**WELWYN HATFIELD BOROUGH COUNCIL  
ASSISTANT DIRECTOR (PLANNING)**

**DELEGATED APPLICATION**

**Application No:** 6/2023/0456/FULL  
**Location:** 5 West View Hatfield Hertfordshire AL10 0PJ  
**Proposal:** Installation of a front and rear dormer to facilitate the conversion of a loft into six habitable rooms and storage, spiral fire escape to the right of the property and erection of two rear outbuildings  
**Officer:** Ms Elizabeth Mugova

**Recommendation:** Refused

Proposed Loft Plan

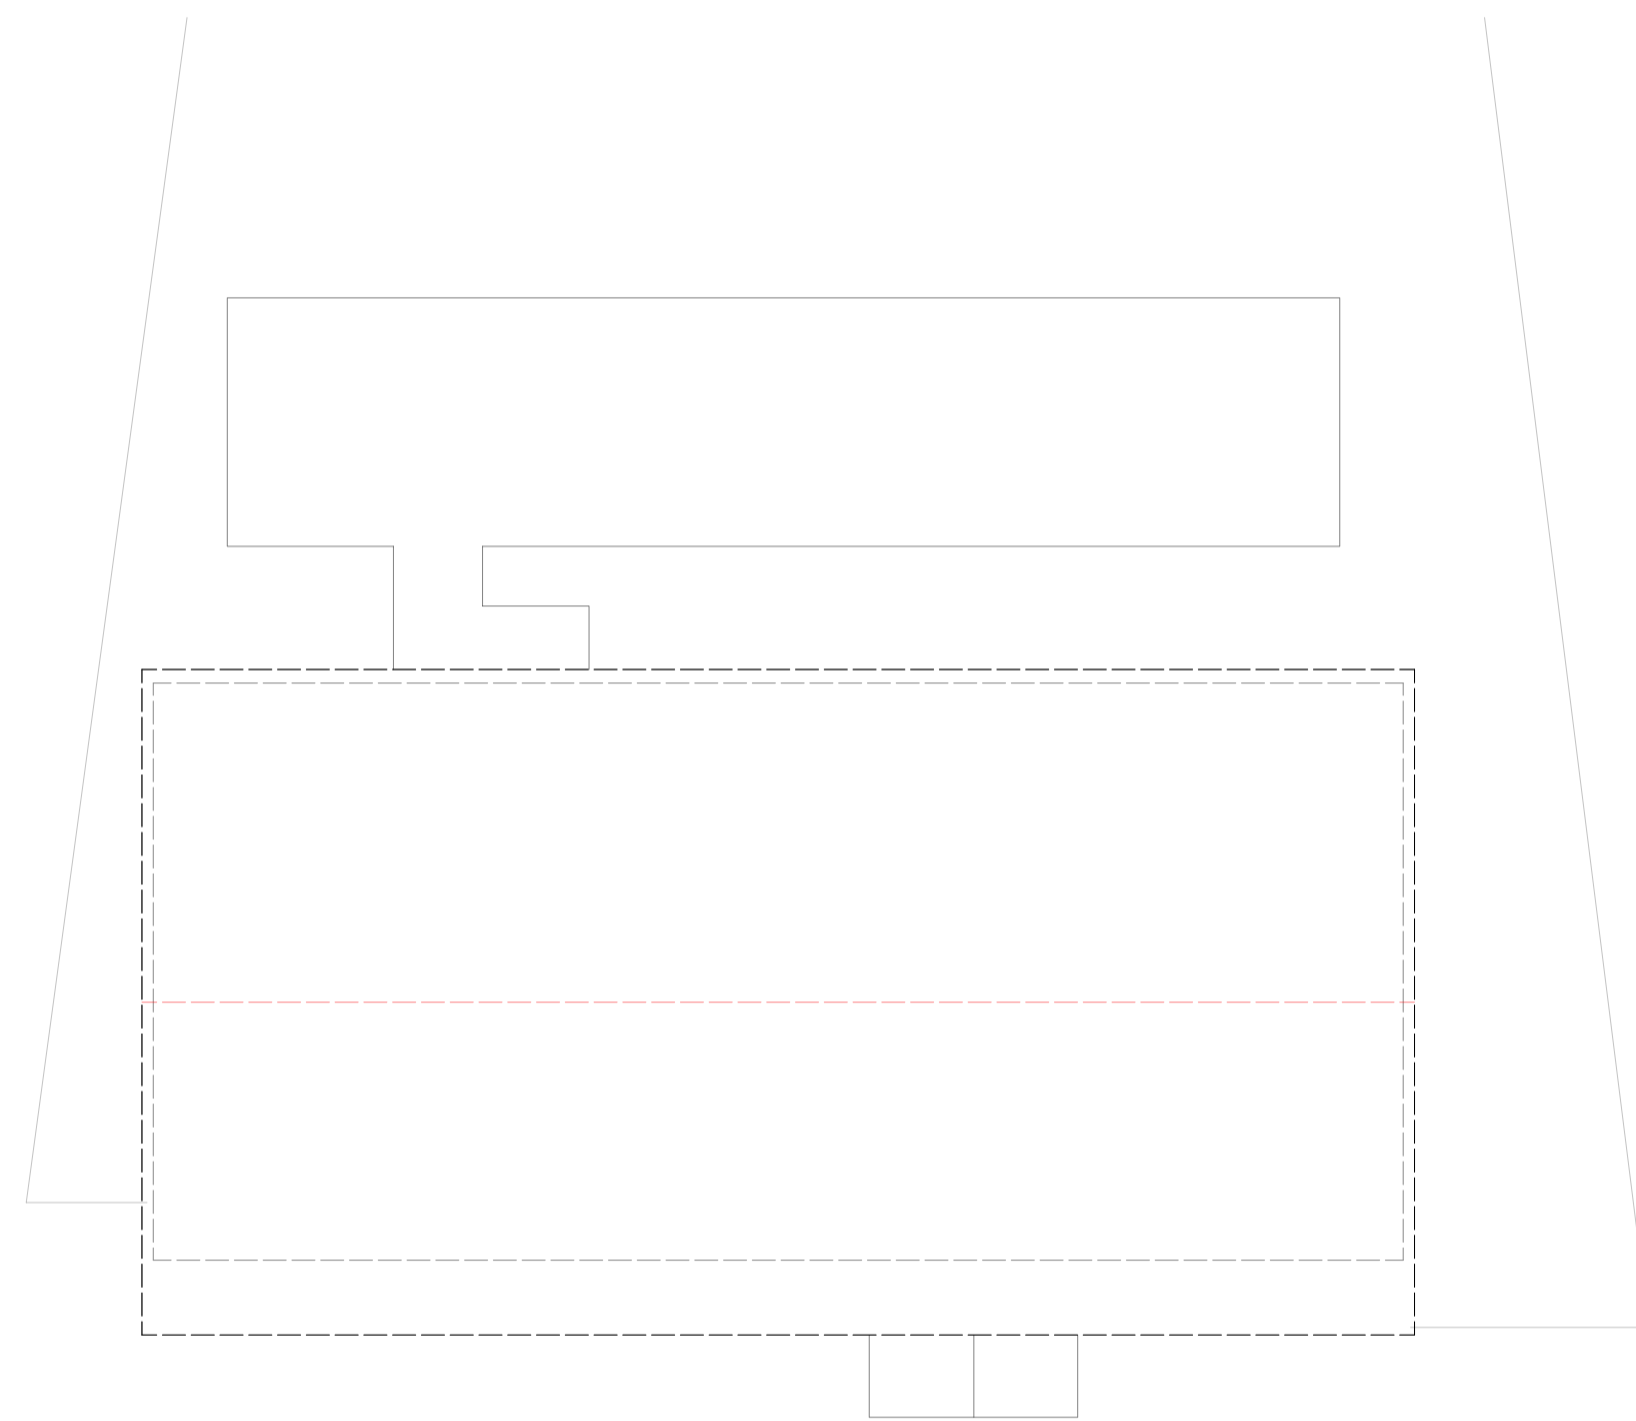
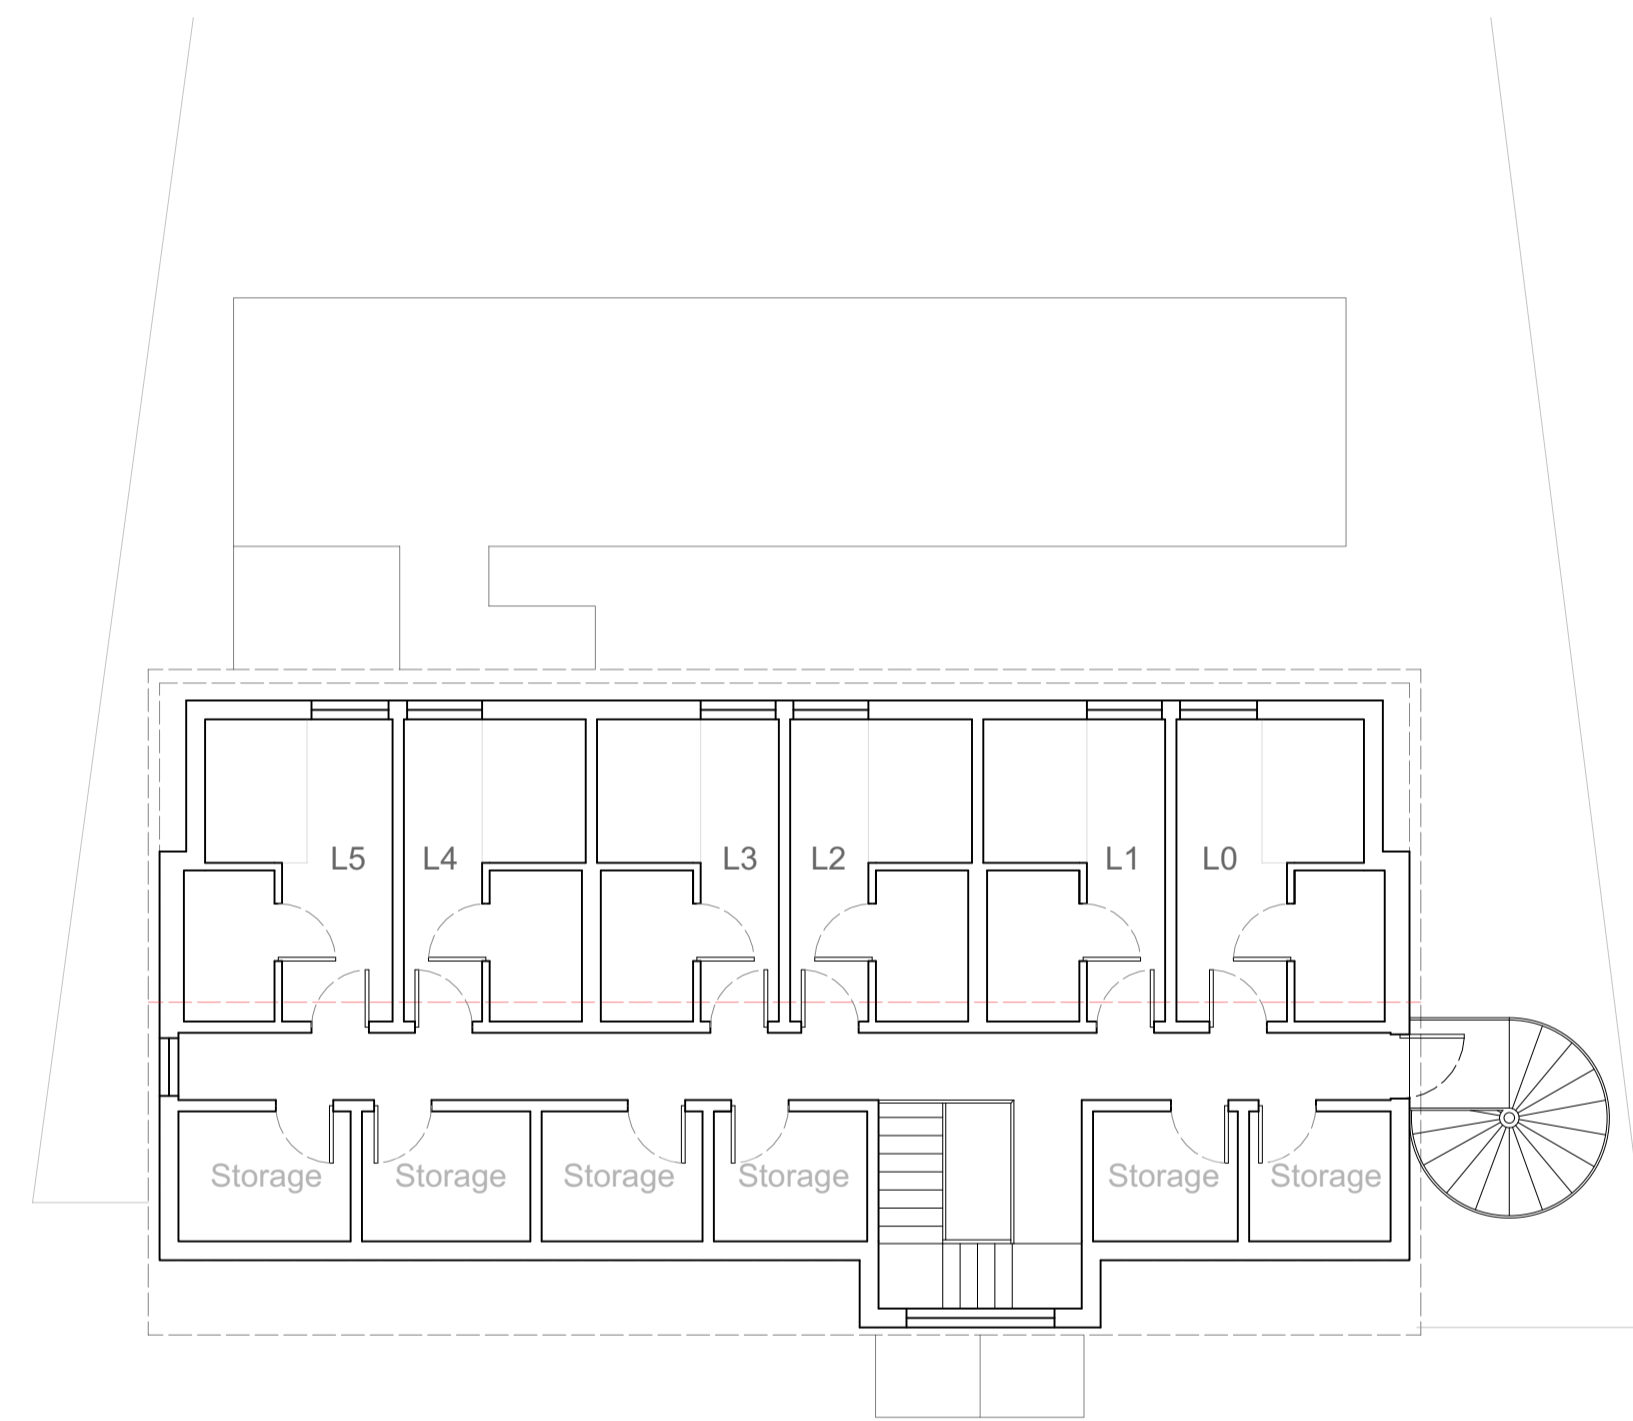
The roof form would be changed from hipped to a pitched roof to allow the installation of the proposed rear dormer. The cheeks of the proposed rear dormer would be set-in by approximately 0.5m from both sides of the flank wall of the property. As such, the rear dormer would be contrary to the guidance set out in the SDG. The size, scale and positioning of the dormer would overwhelm the roofslope, appearing unduly prominent and detracting from the appearance of the host building.

The proposed front roof level extension would manifest itself as a front gable-end pitched roof design and would greatly alter the appearance and character of the existing building. Furthermore, this extension would be unduly prominent within the streetscene, causing significant harm to the character and appearance of the close, to which it would appear alien, and at odds.

Outbuilding 1
 Total Area : 67.2 sqm
 Max Height : 2.5m

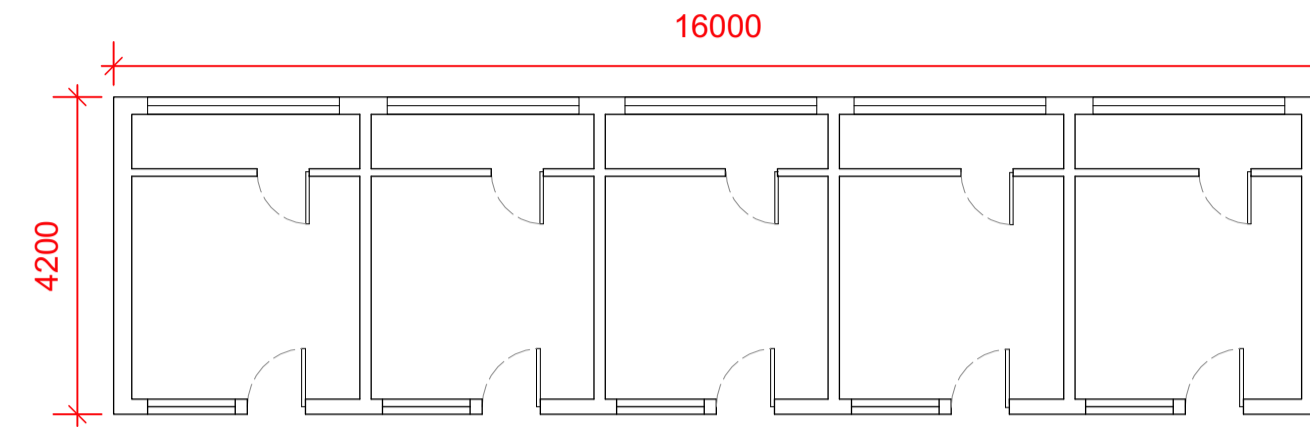
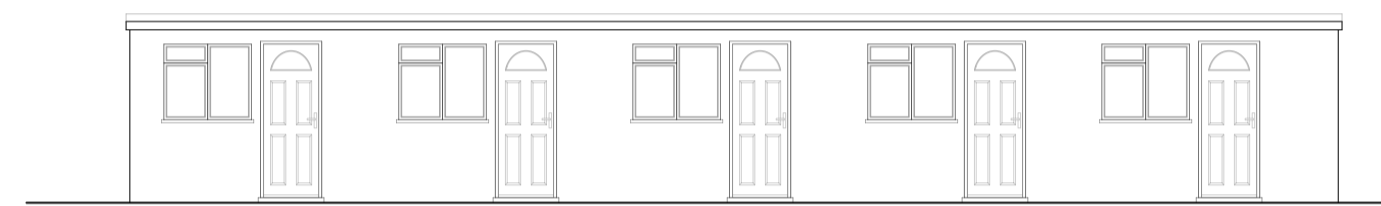
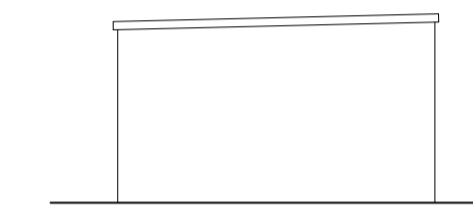
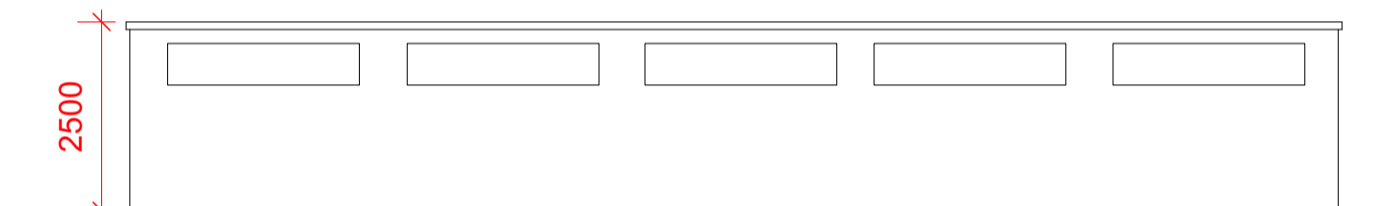
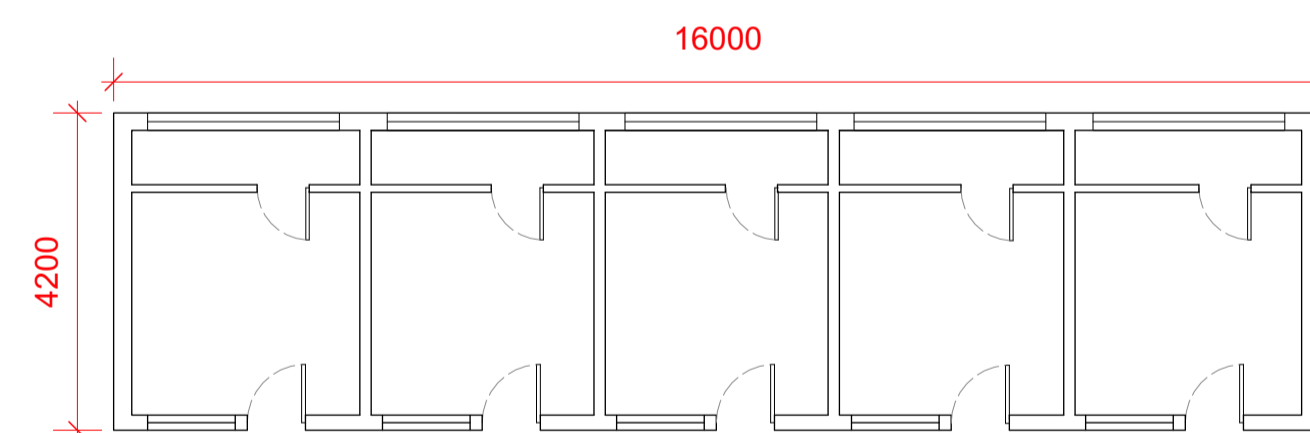
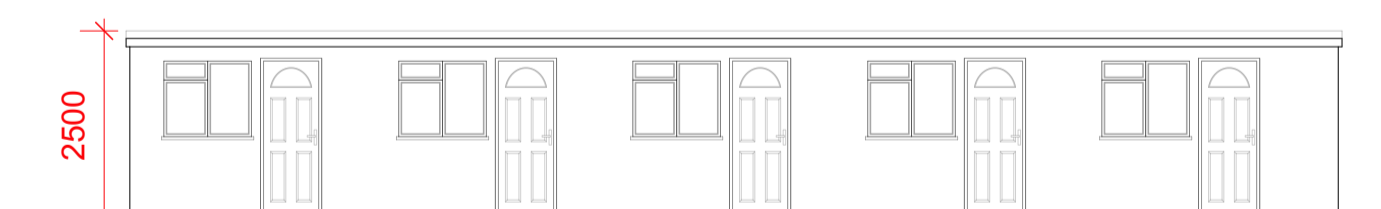
The proposal includes two single storey rear outbuildings each with a footprint of approximately 67m<sup>2</sup>. The outbuildings would have a similar footprint as the host building, and they would be considered as substantial and unacceptable additions to the rear of the property. As such, it is considered that the outbuildings would result in overdevelopment at the application site, causing unacceptable harm to the character and appearance of the site and the surrounding area.

Proposed Side Elevation

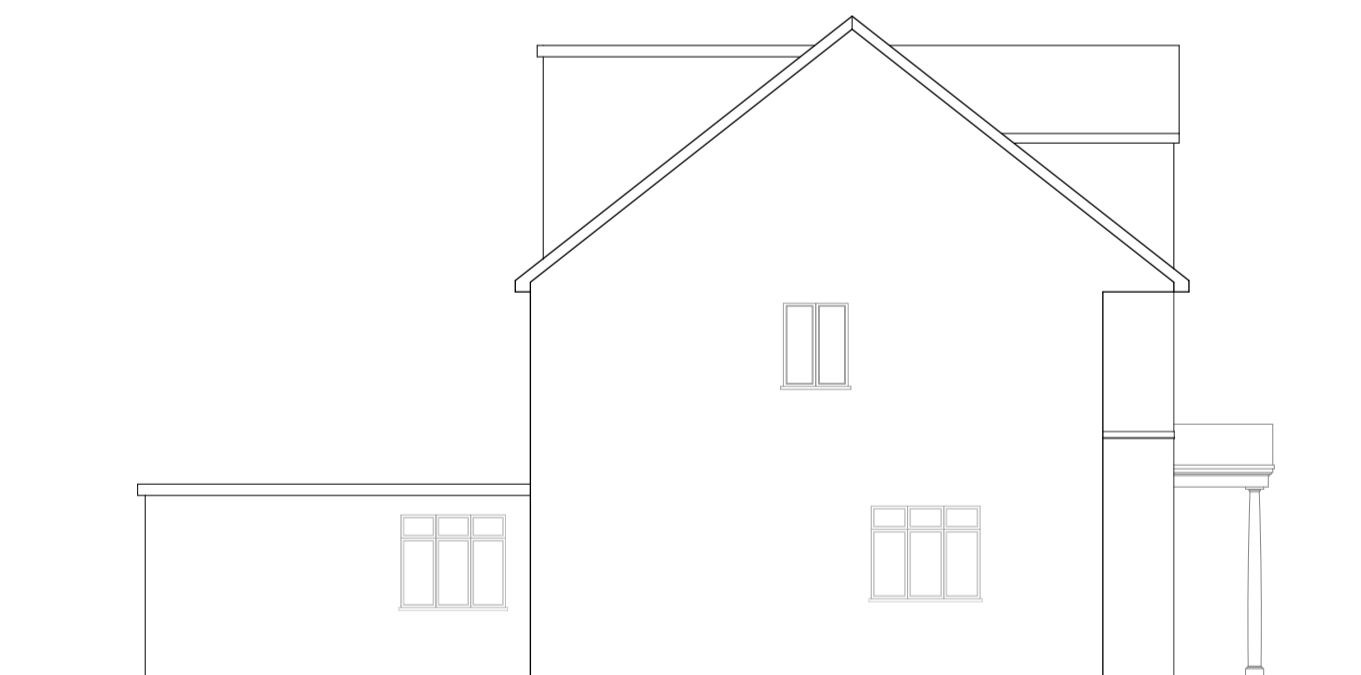
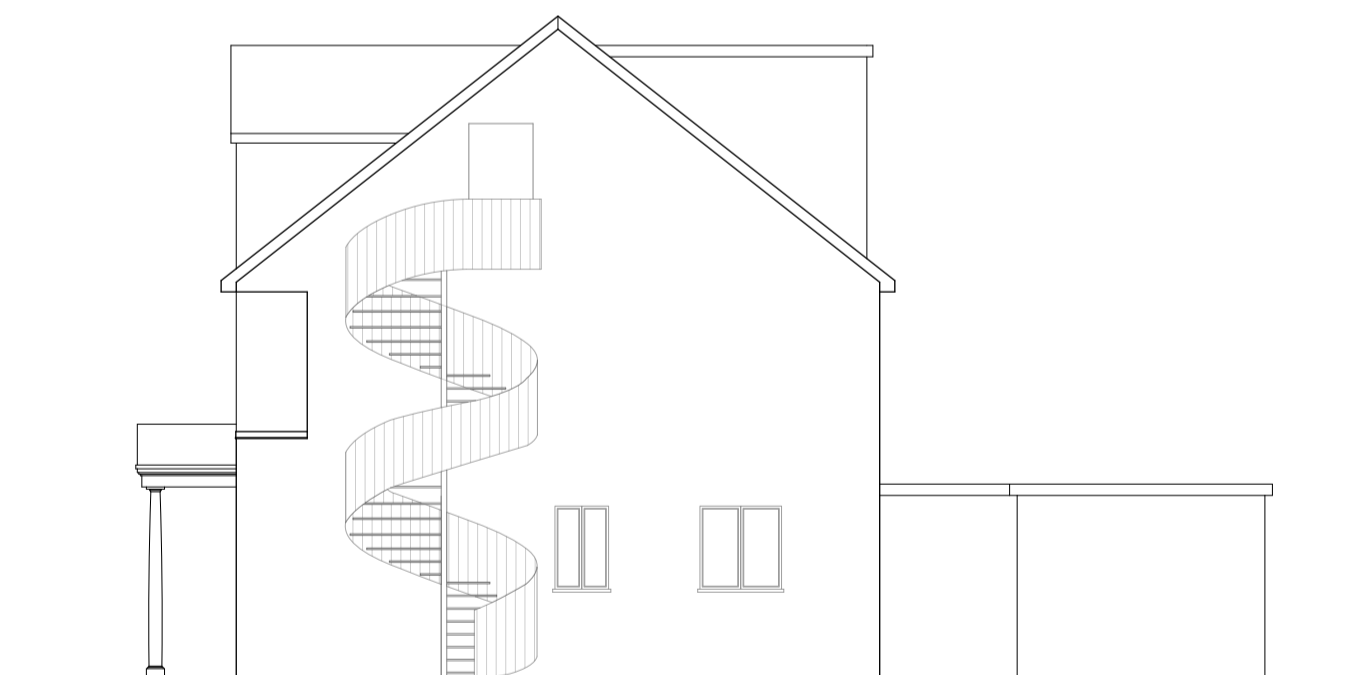
The proposed development would feature an external spiral staircase which would be used as fire escape. It is considered that the staircase would appear visually prominent from public vantage points given its location to the side of the property and would harm the character and appearance of the host building and the wider area.

2. The proposed external spiral staircase, by virtue of its proximity to a neighbouring boundary and the likely nature of its use, would result in unacceptable overlooking impact on the neighbouring occupiers, leading to loss of privacy contrary to District Plan Policy D1; Policy SADM11 of the Draft Local Plan; the Supplementary Design Guidance; and the National Planning Policy Framework.
